City of Albuquerque Stormwater Construction Site Inspection Report

Project Name:	Campo del Norte				
Location:	Signal & Alameda				
Site Contact Name & Agency	Kevin Patton	ESC File No.	C18E102		
	Pulte Homess	NPDES Id. No.	NMR1001LO		
Inspection Date:	02/12/19	Start/End Time:	1100-1130hrs		
CoA Stormwater Inspector:	Timothy Sims, Stormwater Inspector				
Present Phase of Construction:	civil, cutting road grade, constructing walls				
Typers of Inspection:					
	<input checked="" type="checkbox"/> Regular	<input type="checkbox"/> Storm Event	<input type="checkbox"/> Post Storm Event >0.25"	<input type="checkbox"/> 311/Complaint	<input type="checkbox"/> Follow Up

SILT FENCE DETAIL
NOT TO SCALE

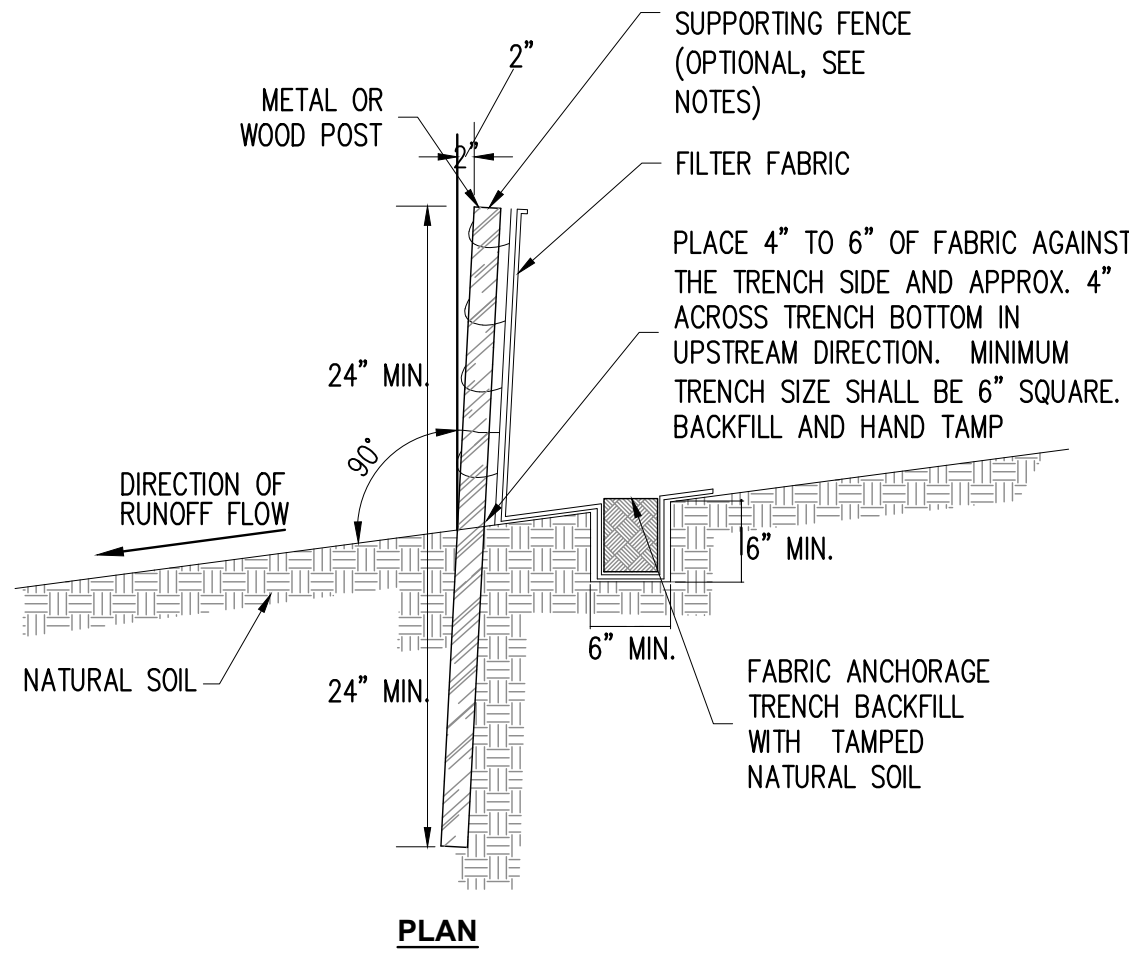
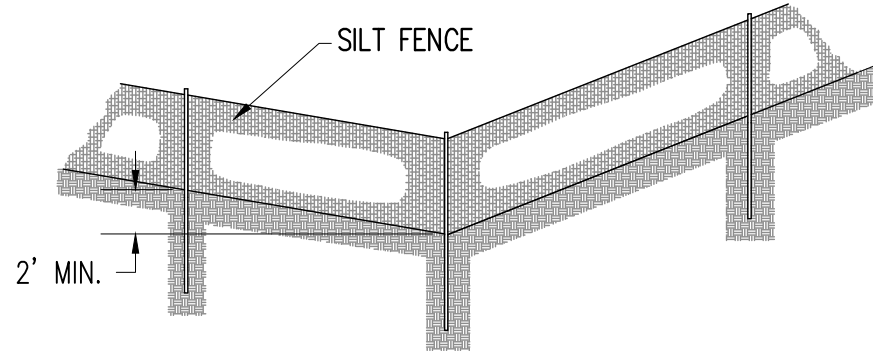
2.2.3	Sediment control along any perimeter		
2.2.3	Sediment control along any perimeter	x	silt fence repair north end of Sugarrite Trail
2.2.4	Minimize sediment track out
